City of Albuquerque Stormwater Construction Site Inspection Report

| Project Name and Location | La Morado Switching Station Vista Creek and La Morado | | |

From: Cherne, Curtis
Sent: Monday, December 07, 2015 12:00 PM
To: 'Brown, Sharon'
Subject: RE: La Morada Substation final inspection-complete
Attachments: sediment-gutter.jpg

STORMWATER POLLUTION PREVENTION PLAN

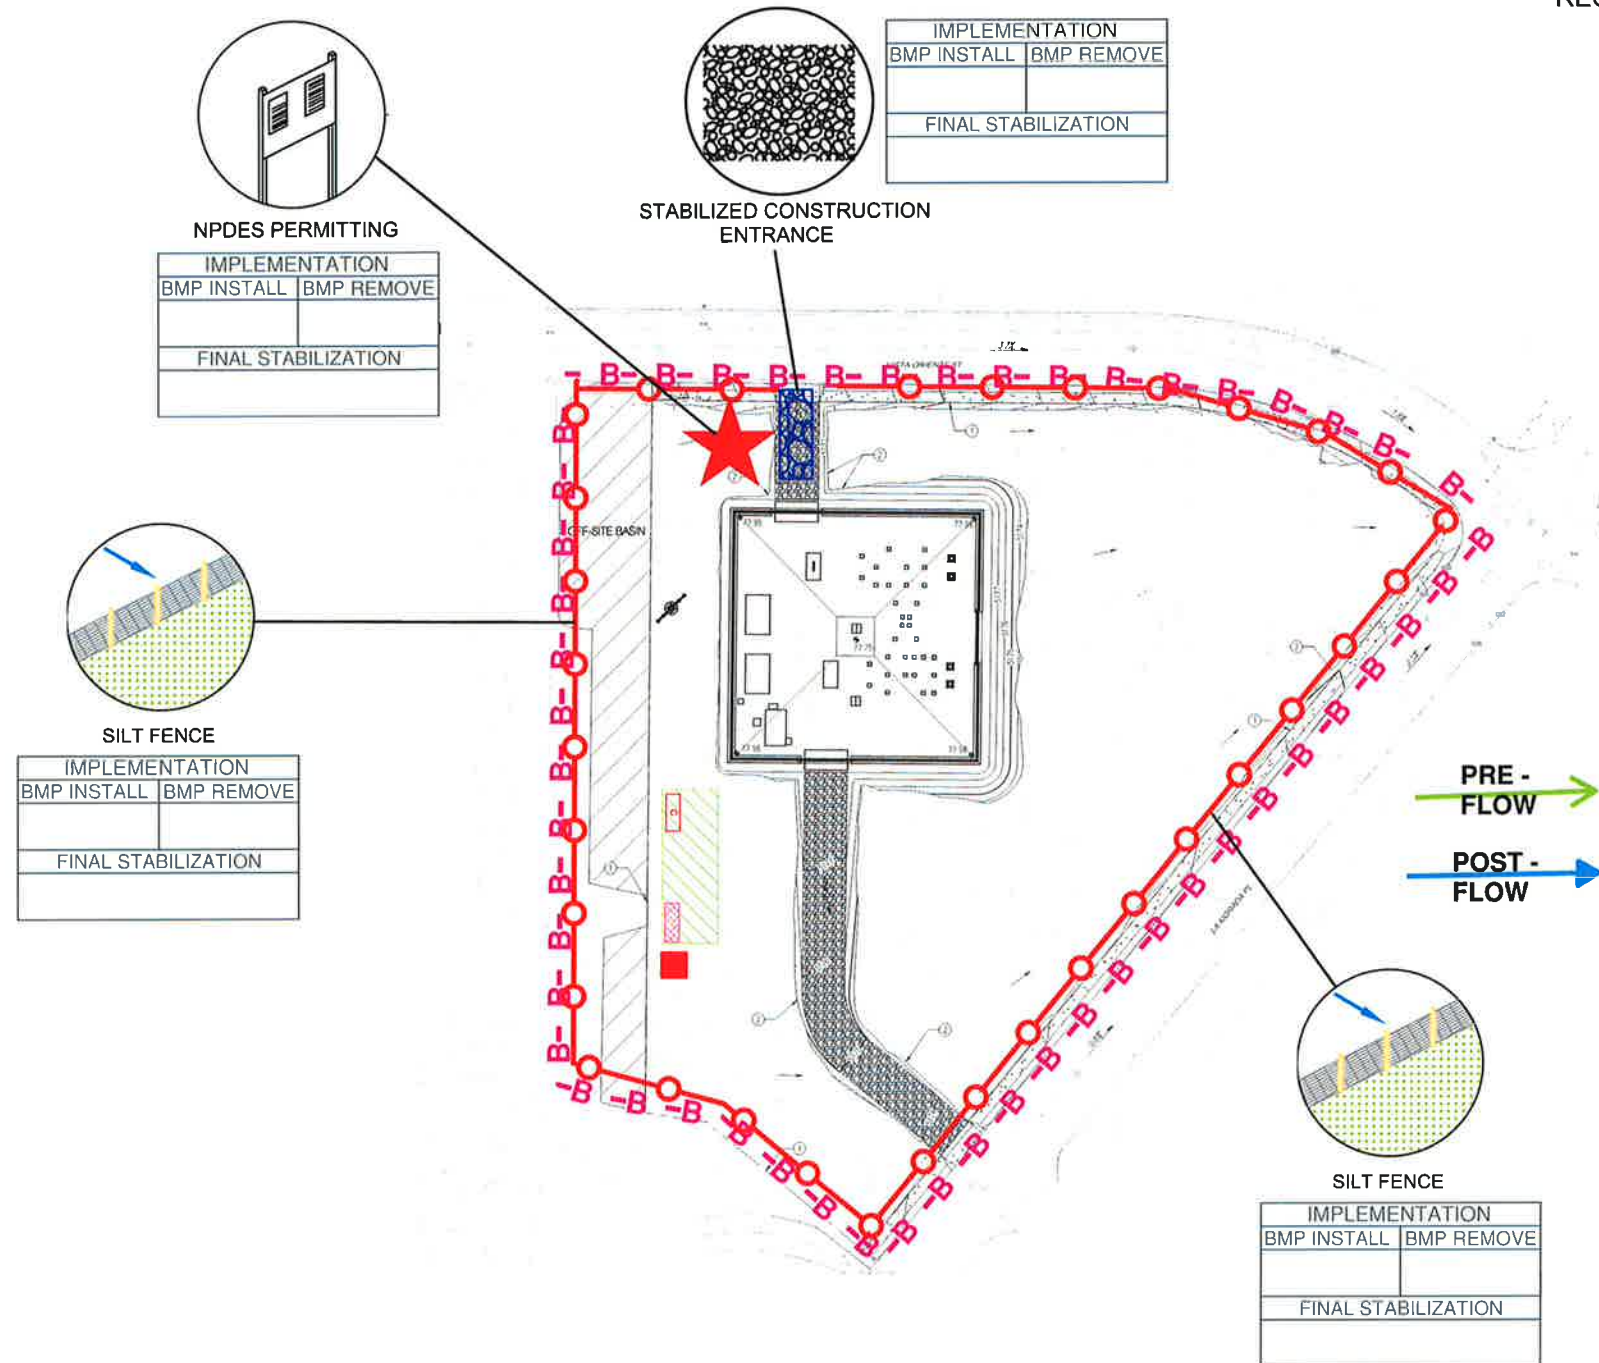
There was some sediment in the gutter along the northern edge of the site. It is not clear to me if it occurred with the project or was existing prior to construction. I will leave it up to you whether it is to be removed or not.
